Rear and side, single and two storey extension incorporating rear balcony. This application affects the Character & Appearance of the Aldwick Bay Conservation Area

3 The Orchard Aldwick

*As owner/occupiers of No.2 The Orchard we are submitting an objection to planning application AW/55/18/HH on the following grounds:*

PROPOSED ELEVATIONS

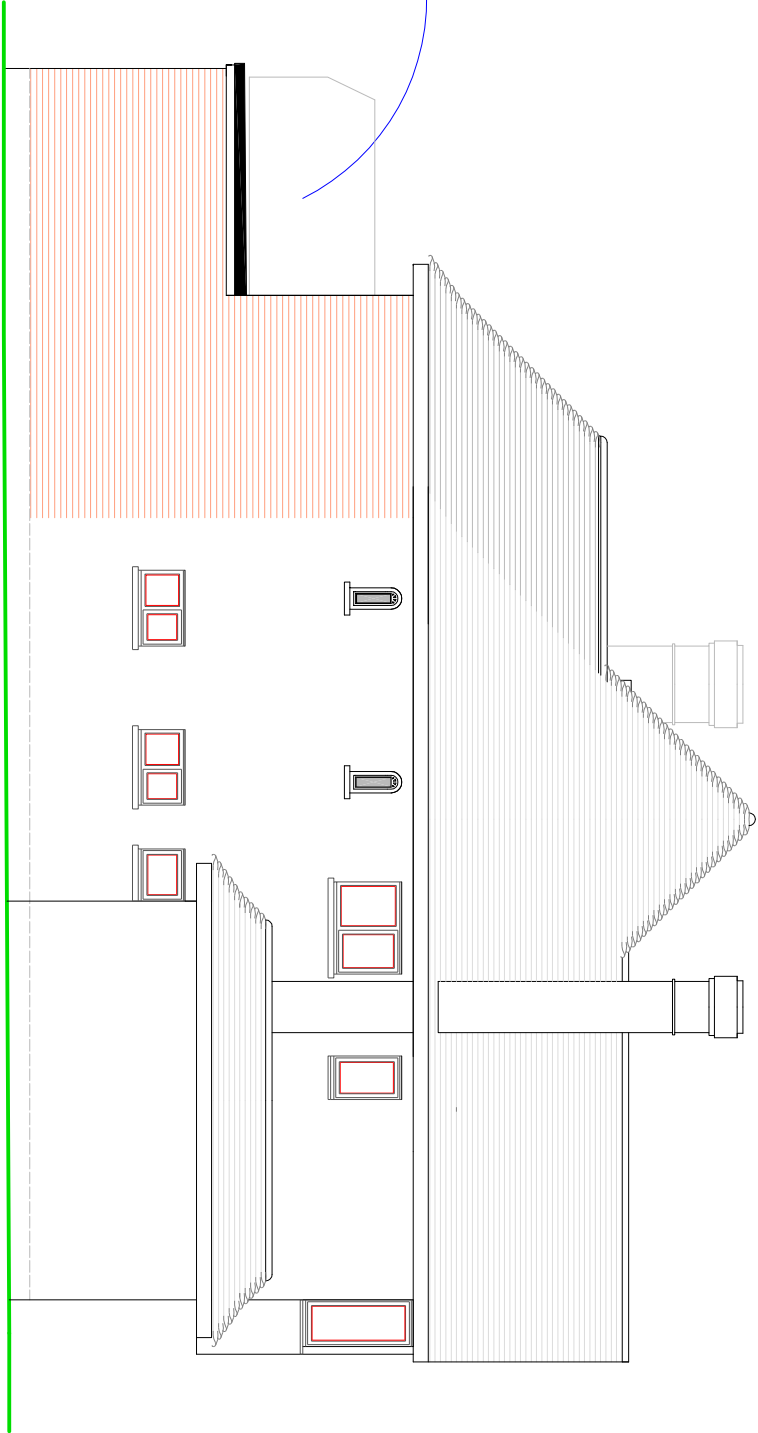
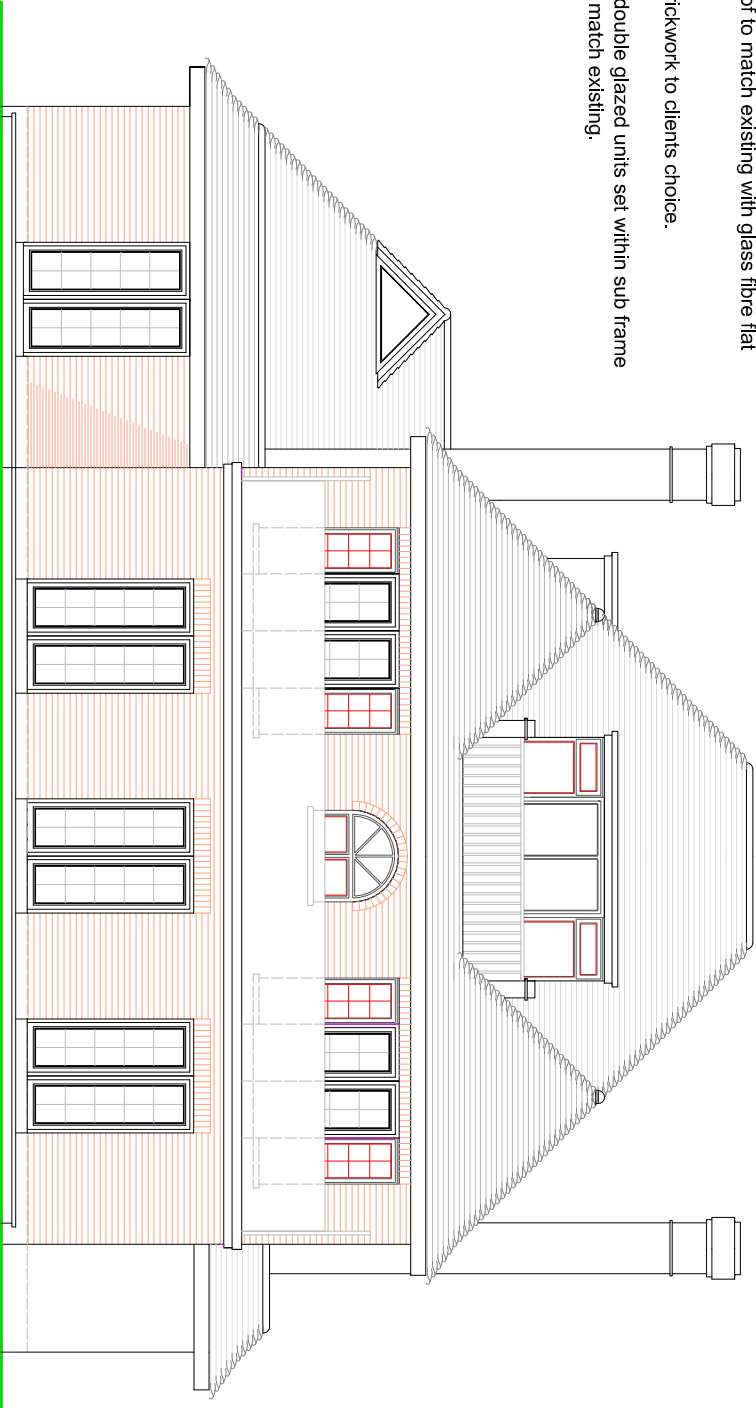
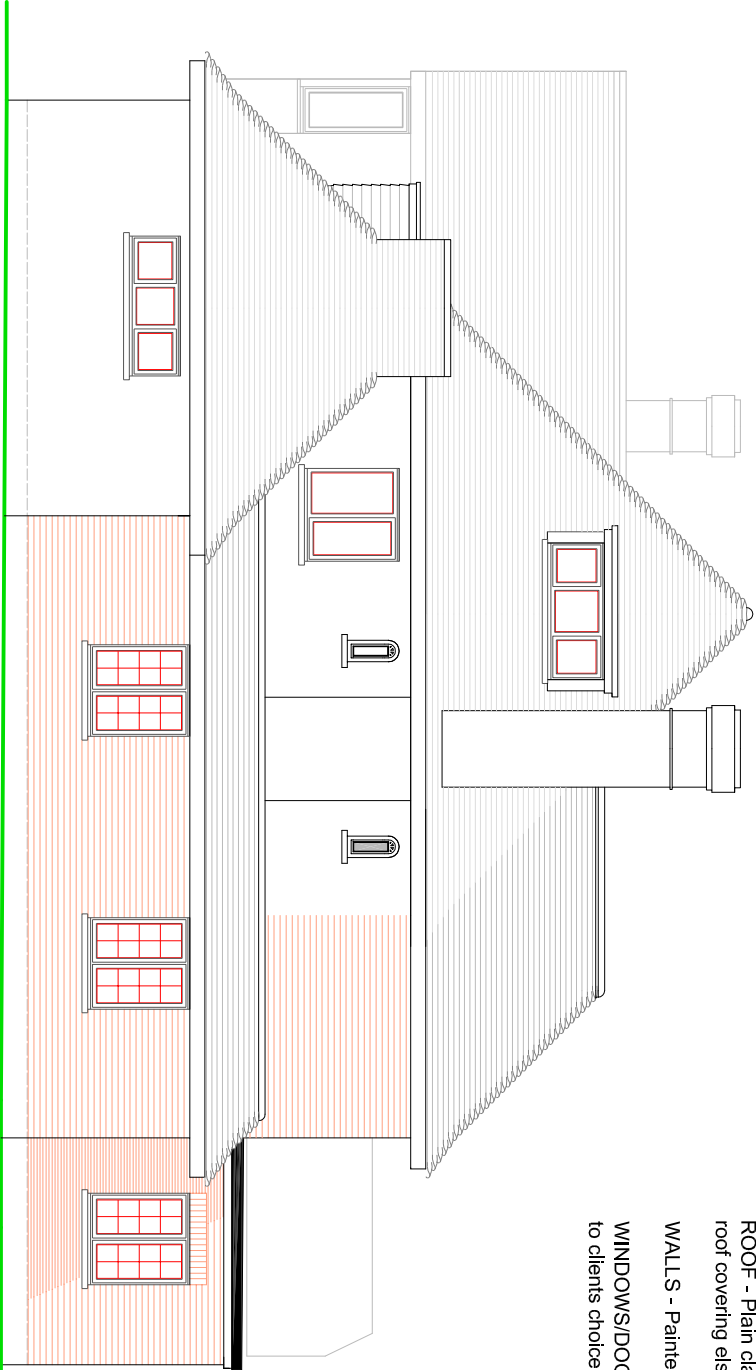
- 1) Our objection relates mainly to the proposed new balcony which constitutes a major intrusion on our privacy. Due to the angles that numbers 2 and 3 sit at on their respective plots it will be possible for anyone using it to see directly into our upstairs study, main bedroom, sitting room and conservatory.*

- 2) The proposed new balcony will totally overlook our garden.*
- 3) The development is a major change in relation to the character of the rear aspects of all the other houses in The Orchard. The new balcony, in particular, with the proposed obscure glazing up to 1.7 metres will be a particularly unattractive feature and totally inconsistent with the concept of the Conservation Area.*
